From: Matthew McCann
Sent: 25 November 2020 18:22
To: Clare Howe
Subject: RE: YMCA- 90 peartree lane

PROPOSED
RESIDENTIAL
OPEN SPACE

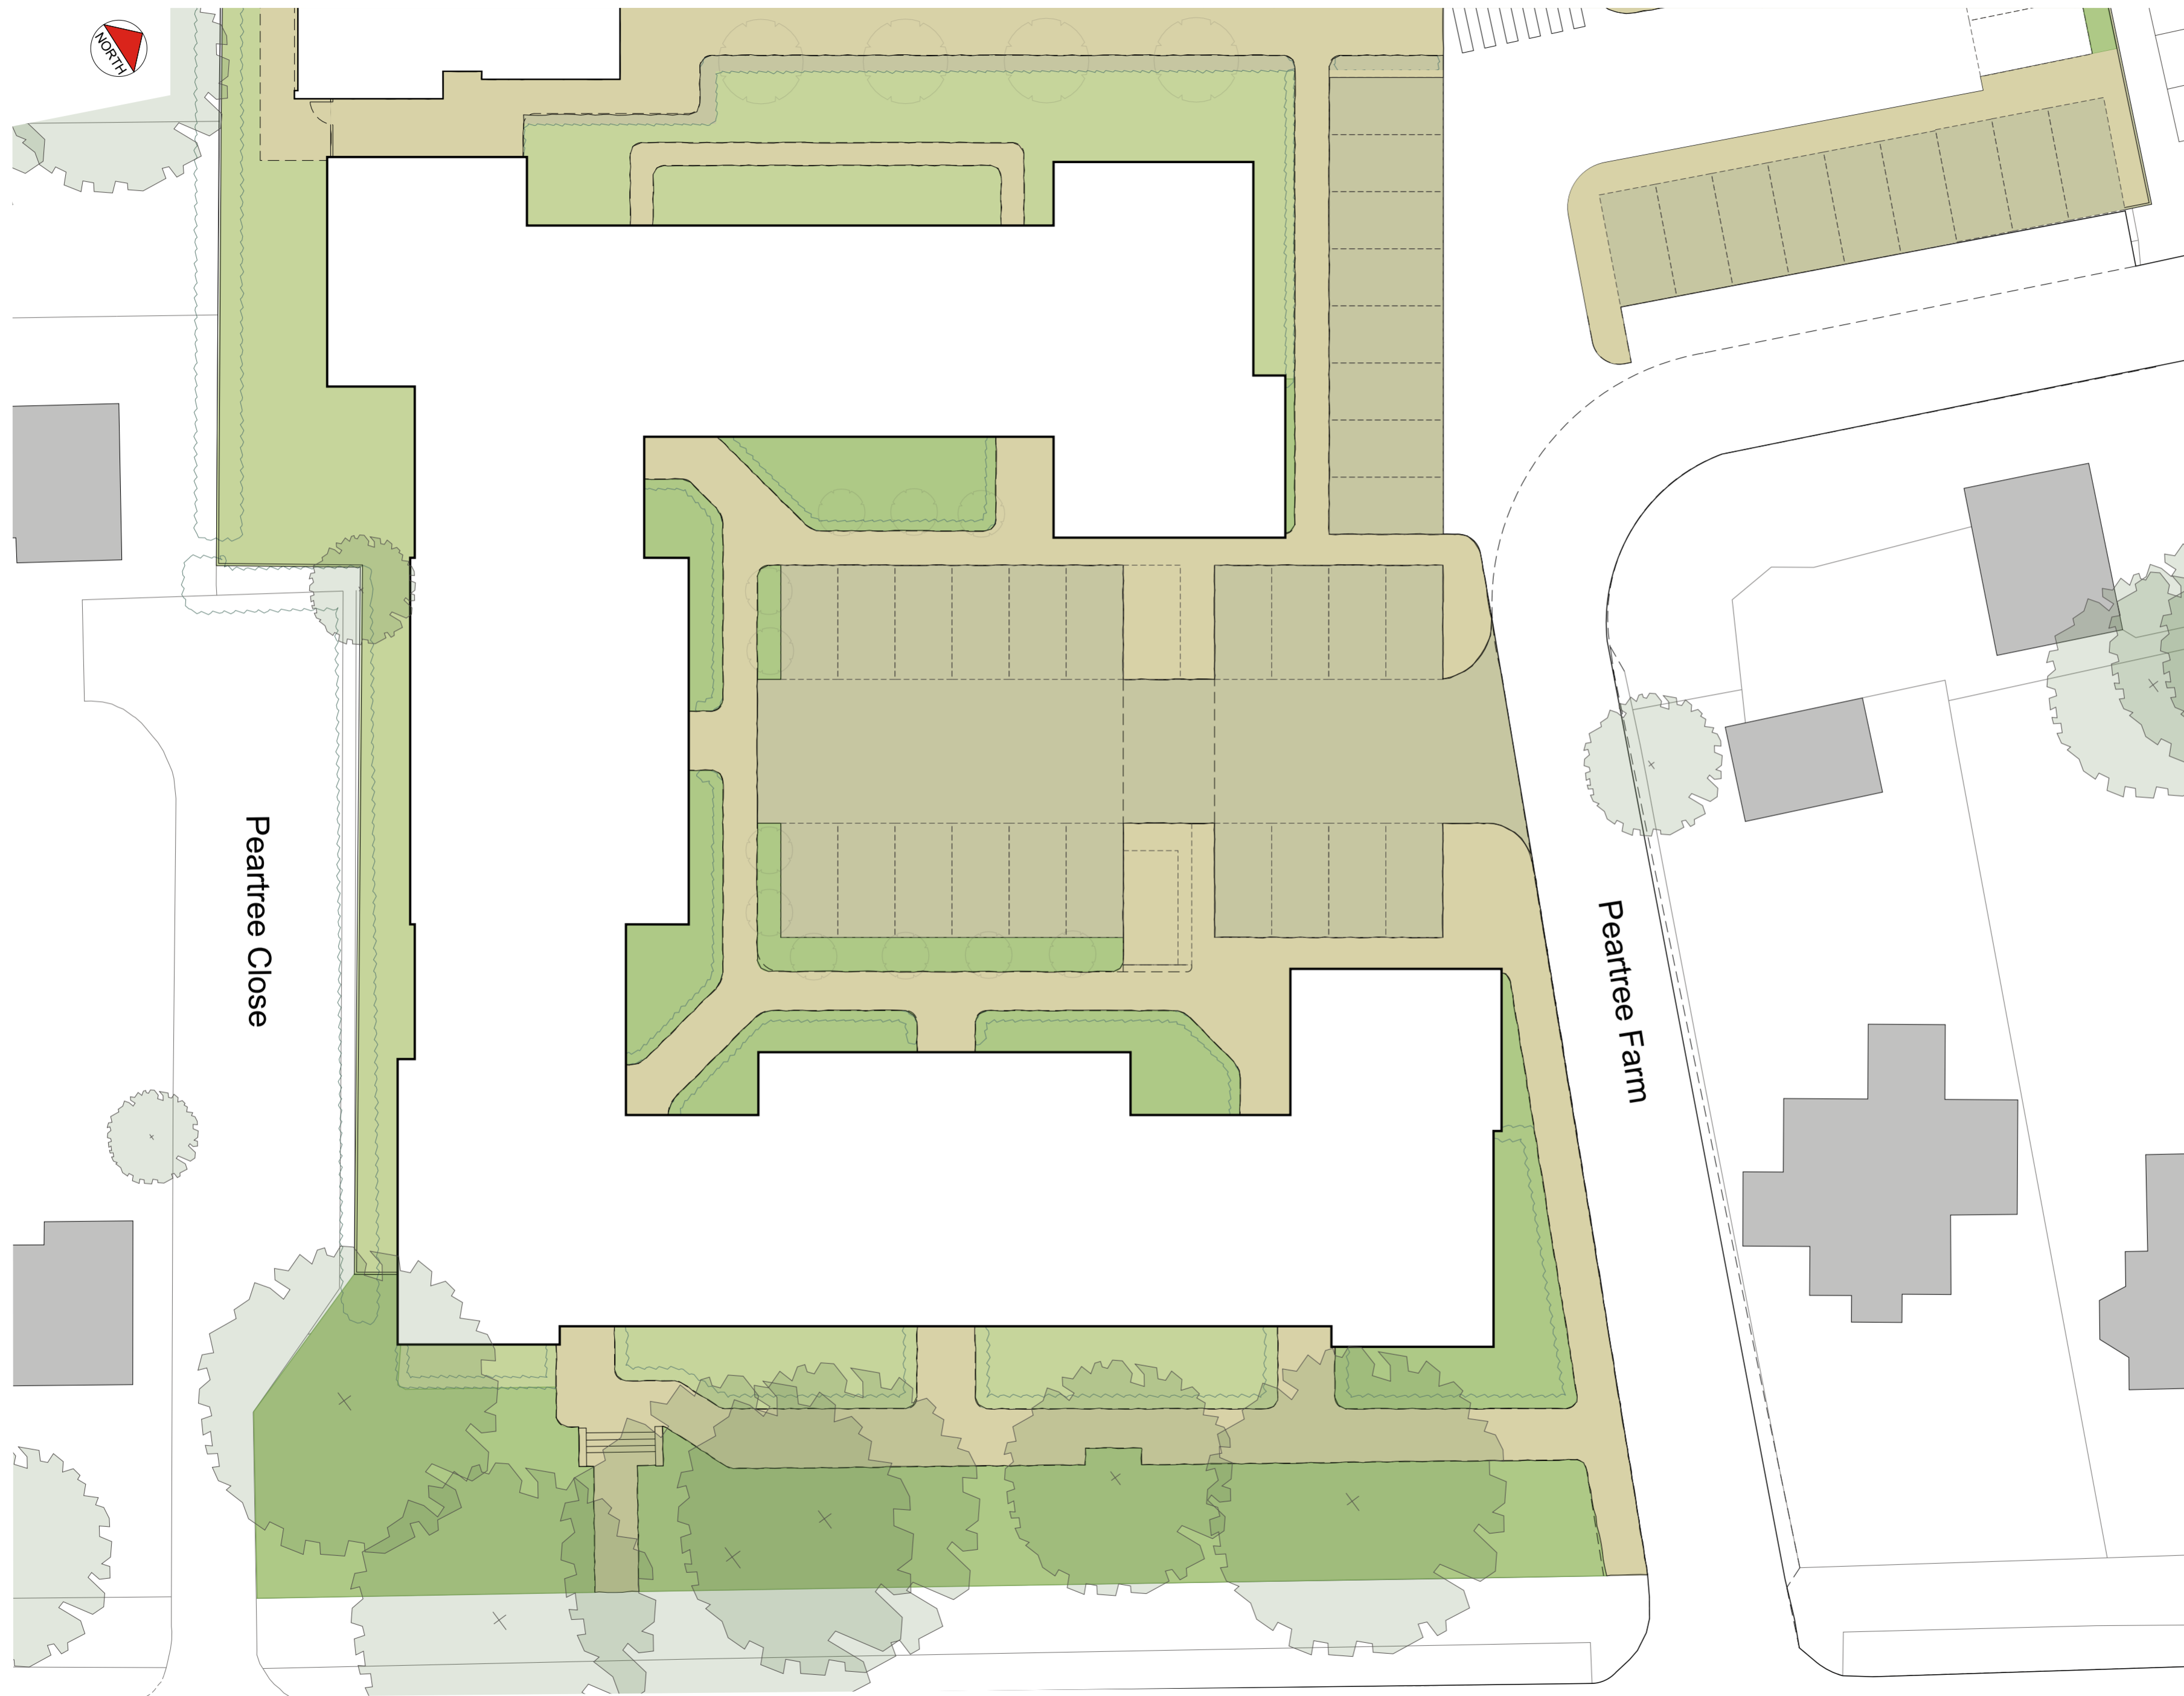
In terms of the comments, I suspect Vikki was highlighting the fact that there is only 29 spaces within the car park, however, I agree there seems to be sufficient parking provided elsewhere (and as long as building services agree as I believe it is a WHBC owned road?)

The parking objection comments states that we have 29 parking spaces for the residential units. This is incorrect we have 39 spaces allocated for the residential units. The allocation for residential/ hostel is indicated in the DAS. See attached snippet of Pg 34.

1 Bed: **22** flats (at 0.75 spaces per flat, parking required is 17 spaces)

2 Bed: **21** flats (at 1 space per flat, parking required is 21 spaces)

Therefore, total parking required, **38 spaces**

Total proposed provision is **39 spaces** (including 1 accessible space)
